12 January 2022

Submission on behalf of

Leslie Brooks

In this submission I am objecting to the proposed amendment on the basis that the importing of VENM/ENM will create an unwanted dust impact and the construction of the visual amenities will have a minimal benefit to blocking off quarry activities for the wider community.

Figure 3 | Existing and proposed amenity barriers

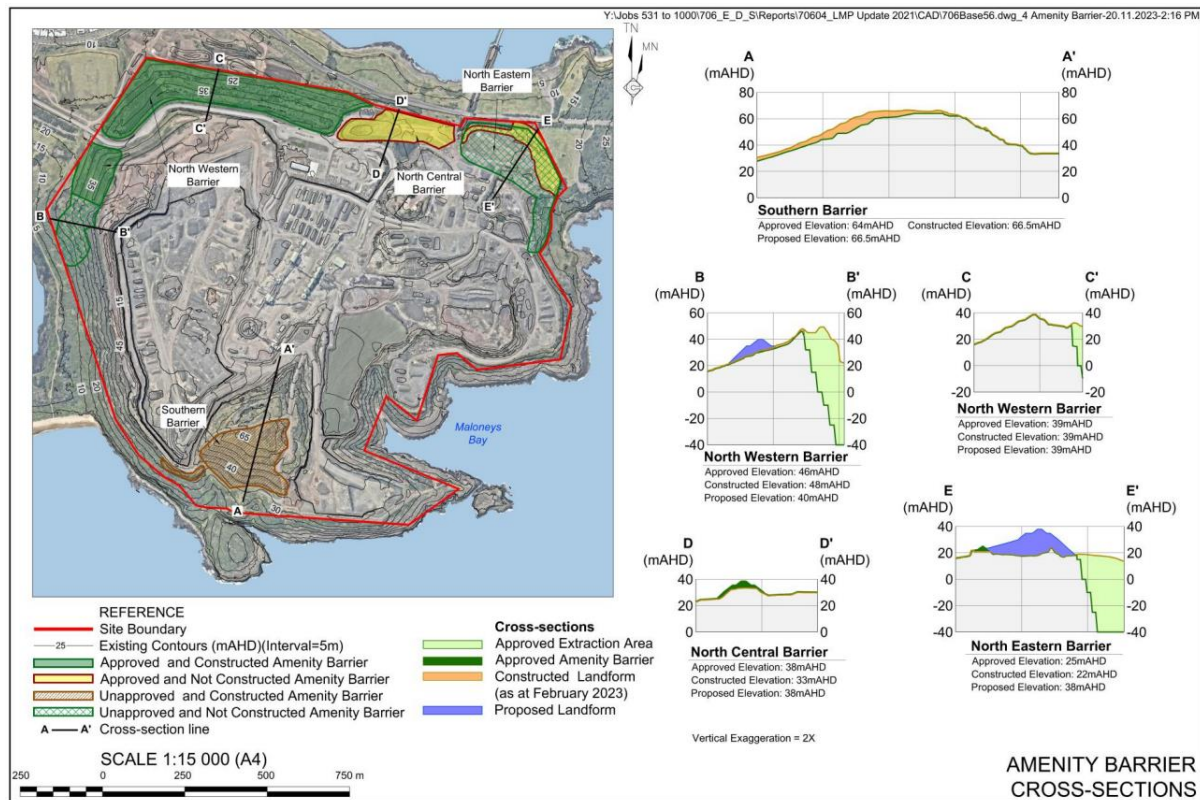
A further reason for my objection is because the Modification document (Bass Point Quarry Modification 3 PA 08_0143) which is open for public comment does not clearly show where visual amenity construction will occur, other relevant details (location/volume/quantity) regarding the materials to be imported to the quarry are missing from the main document.

1. The visual amenities to be modified or constructed are not clearly detailed in the modification proposal. I am requesting the approval document to be revised to include a diagram that clearly shows existing visual amenities vs the proposed visual amenities, the diagram needs to allow the general public to understand the locations where the visual amenities will be constructed or modified. Refer to the attached diagram as an example to clearly show the proposed work of the visual amenities to be constructed.
